Memorandum

Subject: Major Project Application Reference 10_0071. Sydney CityGrid – Stage 2A(i) City East Zone Substation

5.7.2. O’Connell Street Schematic Elevation

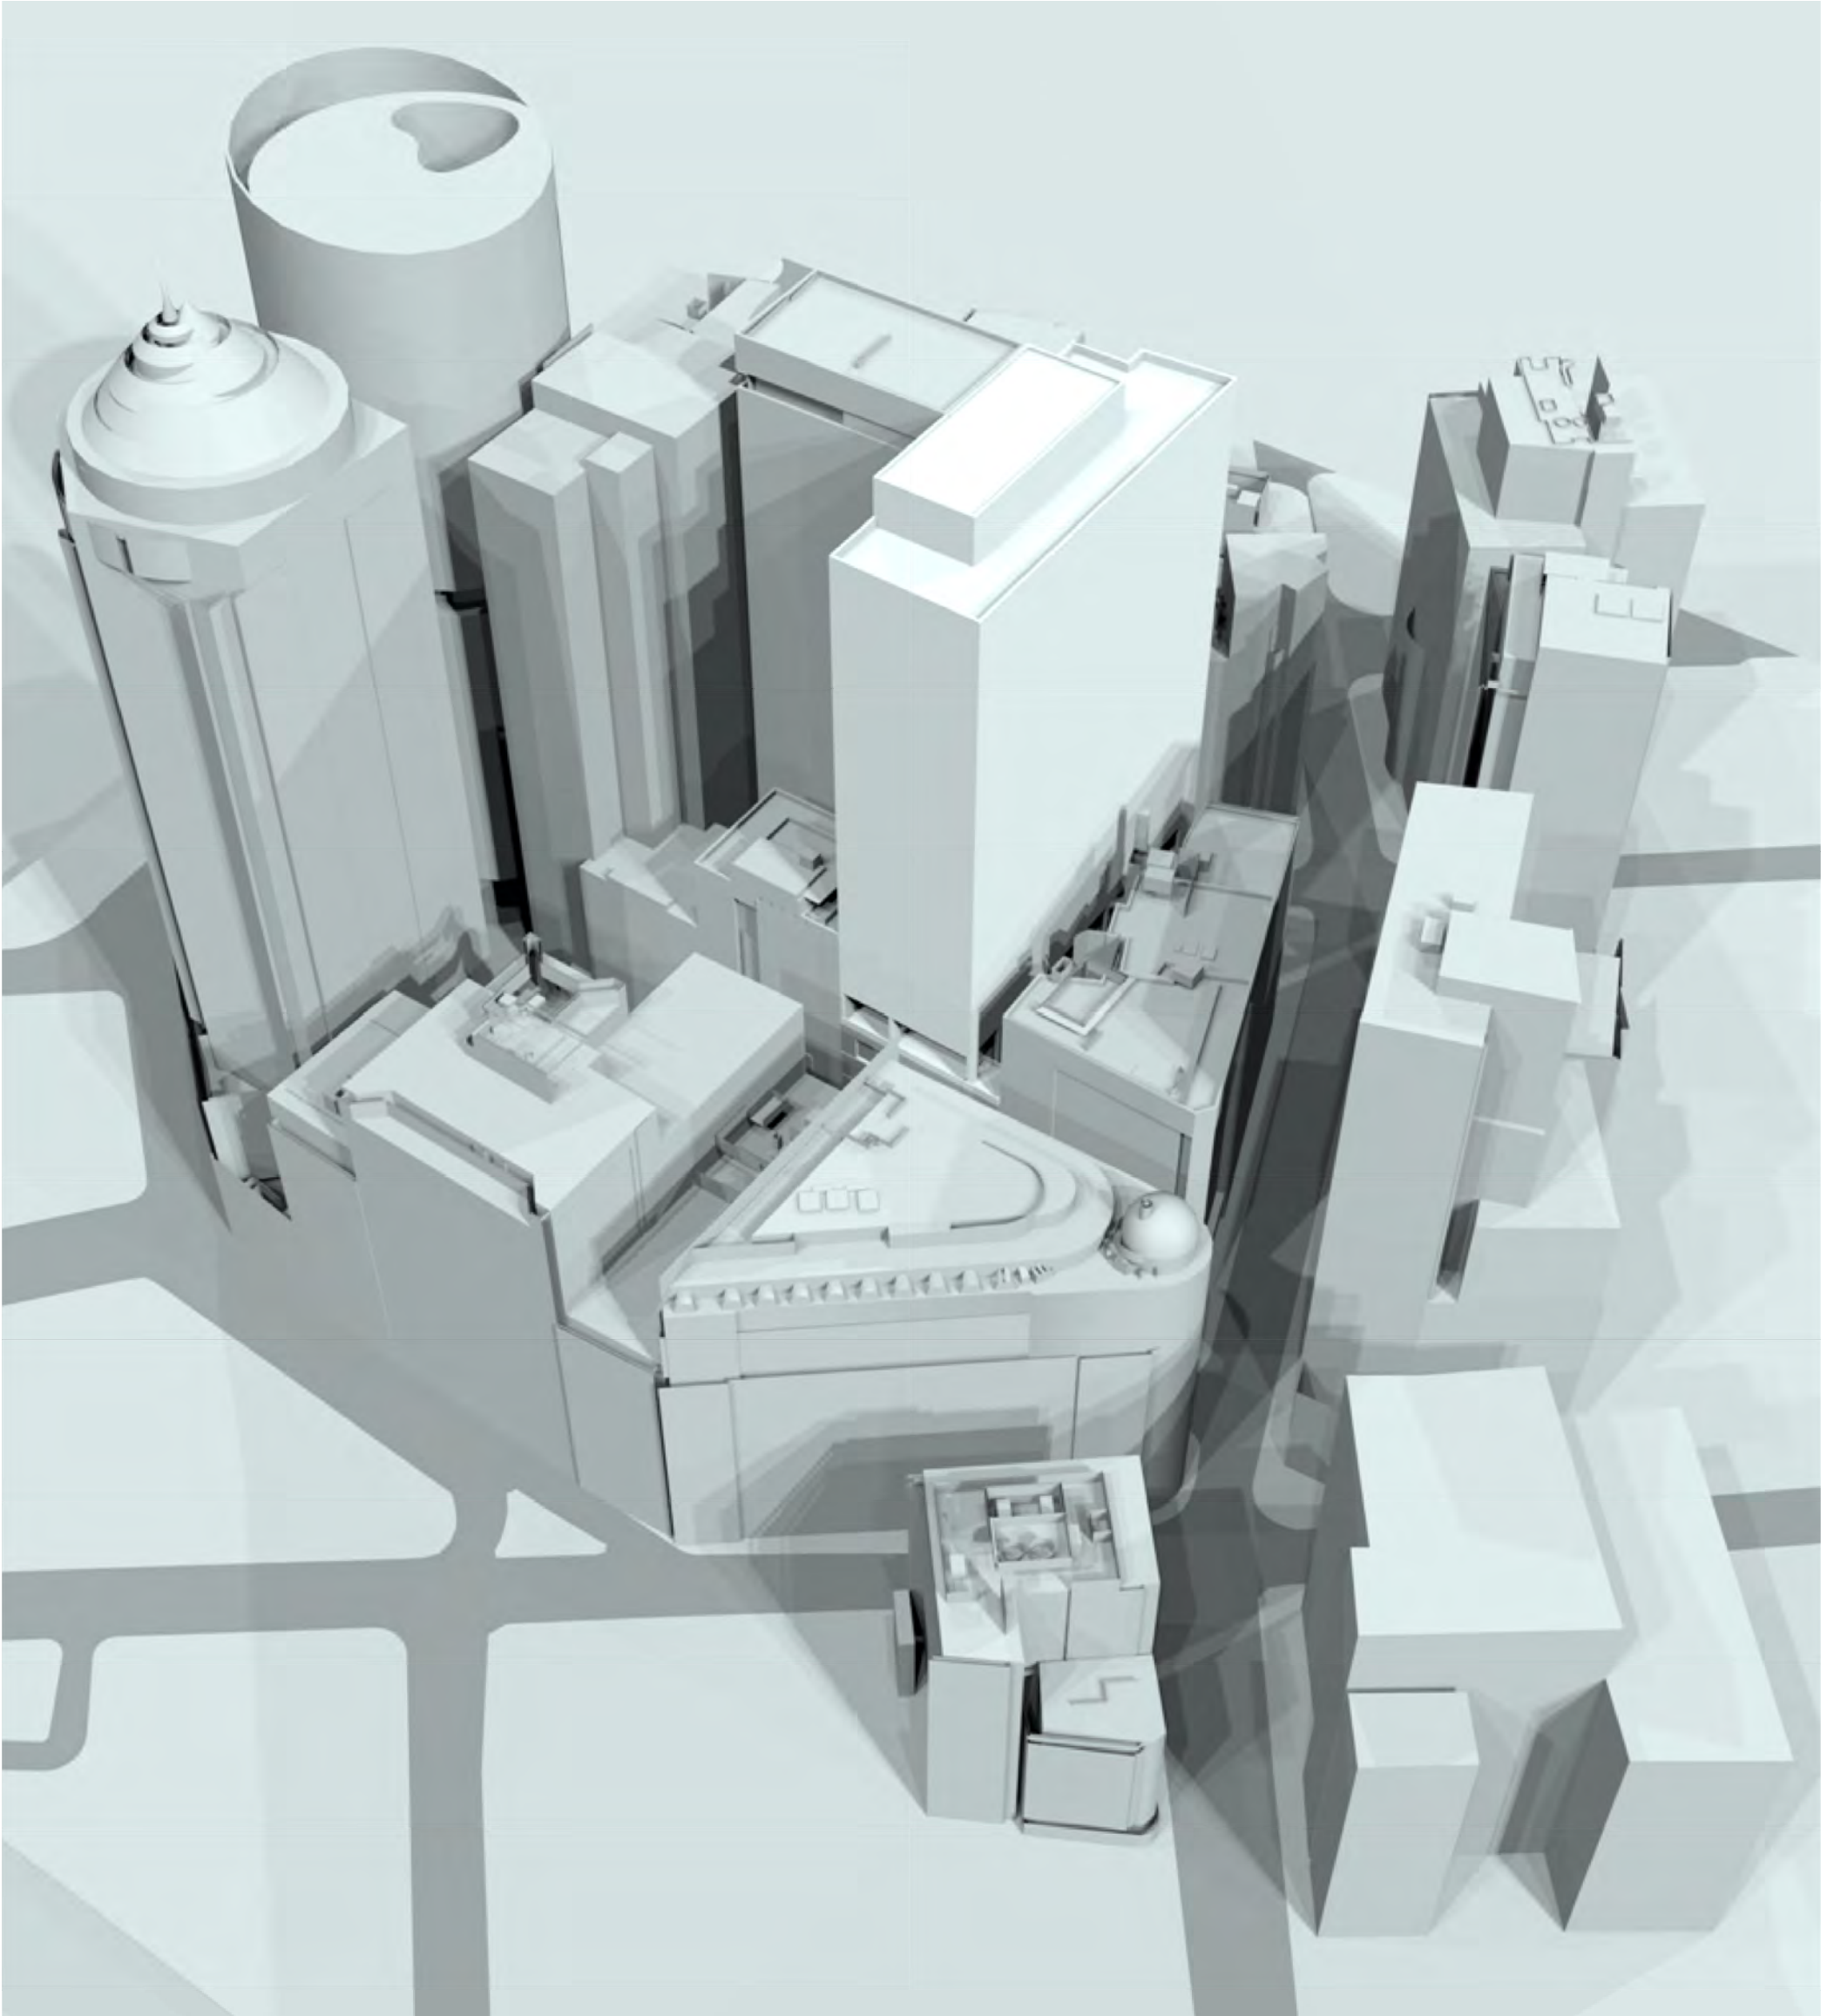
- *The O'Connell Street elevation requires greater modulation than is apparent in the massing studies and could be achieved through the use of a variety of materials, articulation and modulation of the podium. This would be considered during Stage 2(ii) of the City East Zone Substation; and*
- *The southeastern corner to Bligh Street is a critical corner and presentation to Richard Johnson Square and Hunter Street. During Stage 2A(ii), care should be taken in the articulation of this corner to the substation.*

The above comments are supported by the Heritage Branch, and it is noted that the Statement of Commitments includes (page 130) a design review process to be undertaken for Stage 2A(ii) of the project. The SOC's are considered sufficient to manage the impacts of the project.
